From: Martyn White
Sent: 05 April 2019 15:46
To: Planning.Responses
Cc: Amber Willard
Subject: BE/12/19/L

BE/12/19/L

The Listed Building Consent application covers an extensive number of areas of work. Based on my understanding, the following are proposed:

View of part of the house thats getting Marley Cedral Click

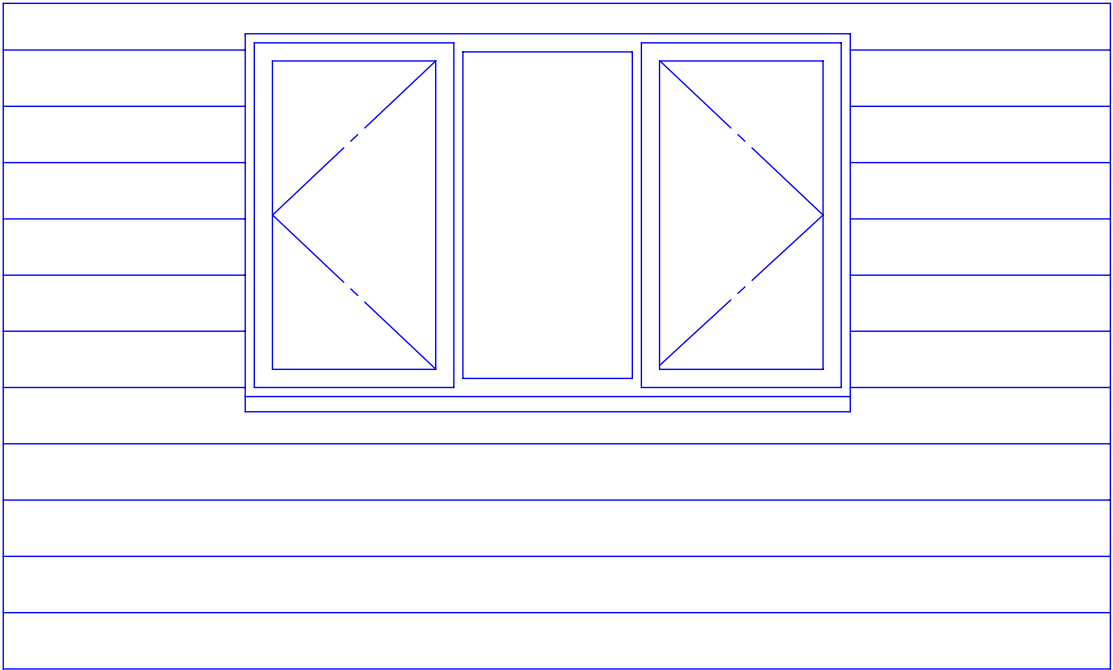
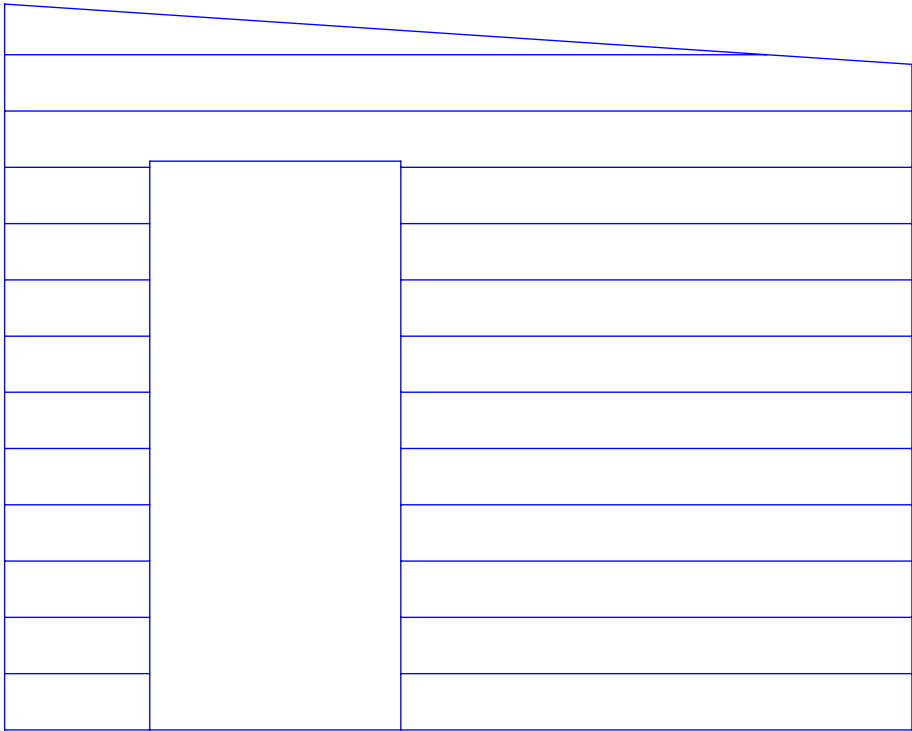
The proposal to improve the design/appearance of the single storey structure is supported. However, at present, it is considered that the proposal will detract from the character of the building, and the proposed materials will harm its significance. It is recommended that traditional materials are used on this element of the building in order to ensure that it reflects the character of the main listed building. the use of UPVC windows cannot be supported in this location.

Plans showing work to be done at cottage

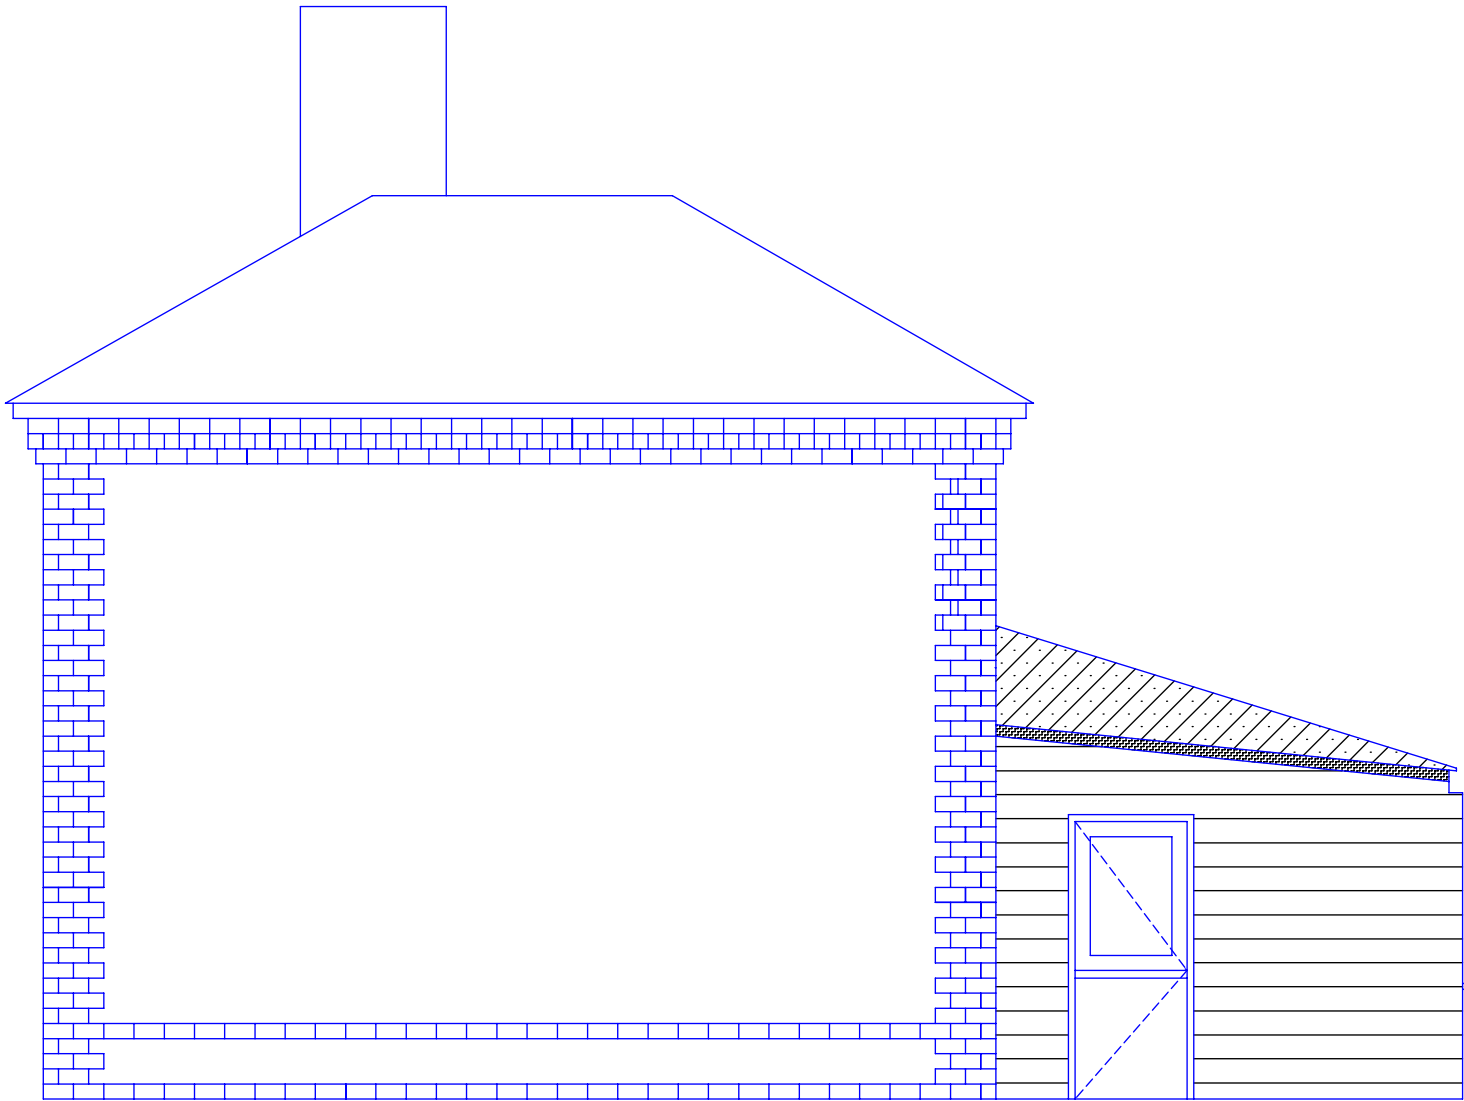
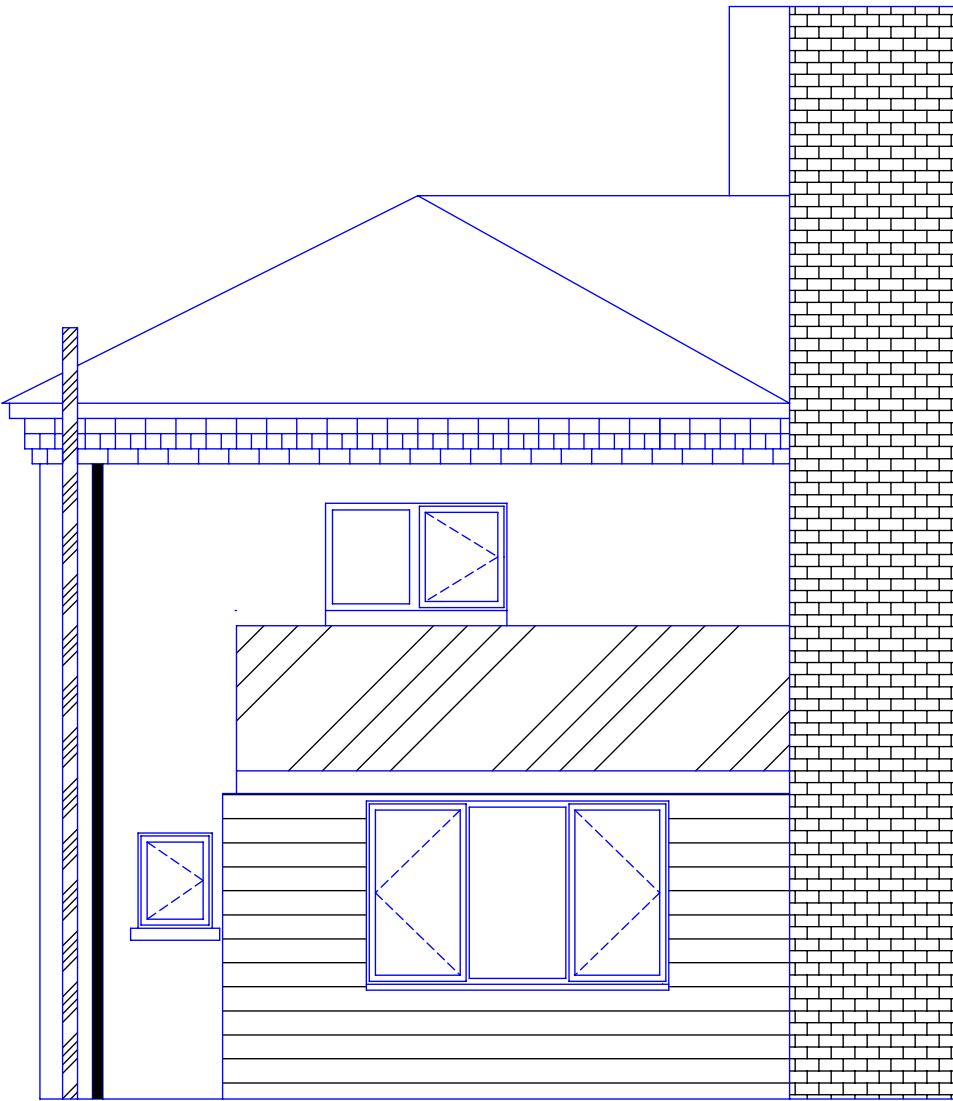
The proposal to replace the bathroom and bedroom windows with UPVC ones is inappropriate, not only in terms of the materials proposed, but also the design of the window. I also note that the intention is to use plastic triple glazing. Current guidance from Historic England is that slimlight sealed glazed units may be considered acceptable in limited circumstances. The use of plastic glazing is also not considered appropriate for the listed building, and like other elements of this application, should be constructed from traditional materials.

Likewise, the use of composite doors does not recognise the character or significance of the building, and cannot be supported from a conservation perspective.

Plans of changes to cottage

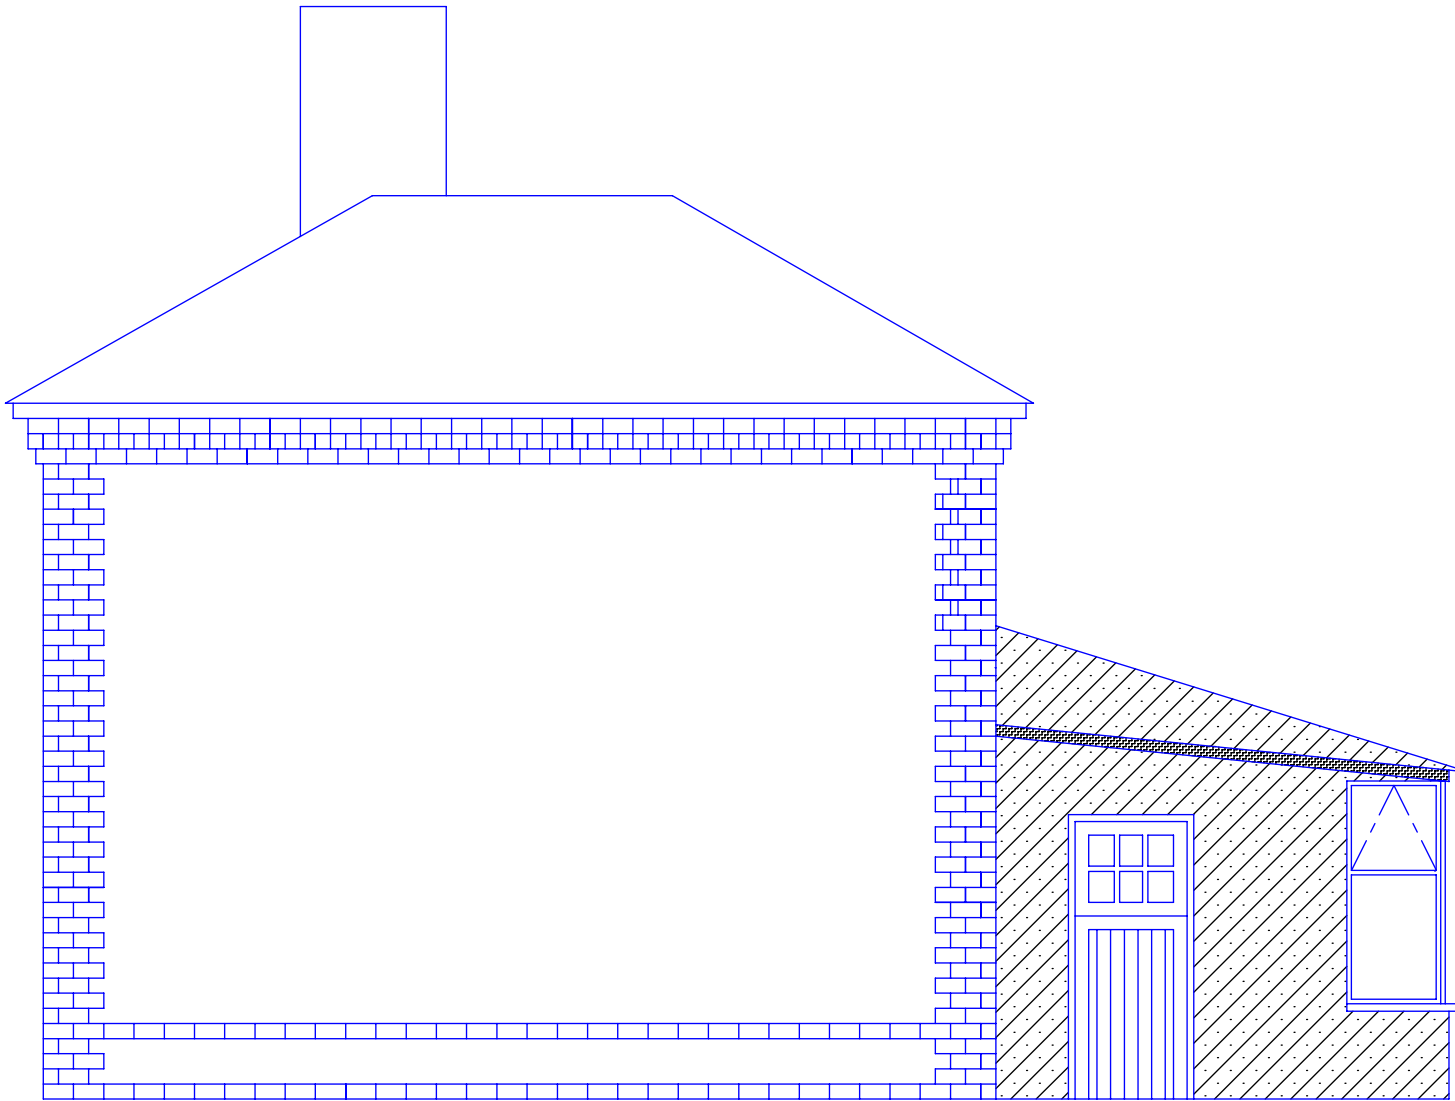
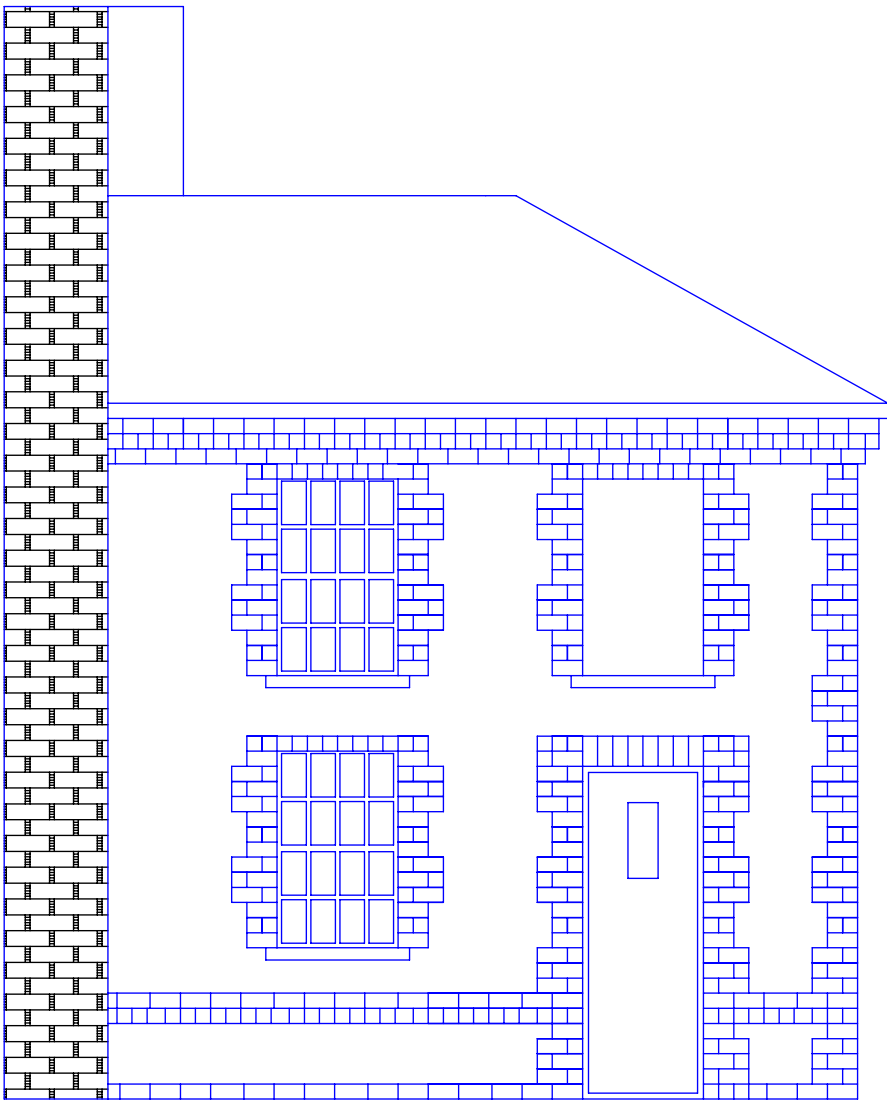
The existing guttering is constructed from plastic, and the intention to replace it with deep fill cast iron effect guttering, is considered to be an improvement. The information supplied is such that it is not clear what design is proposed, and this should be supplied.
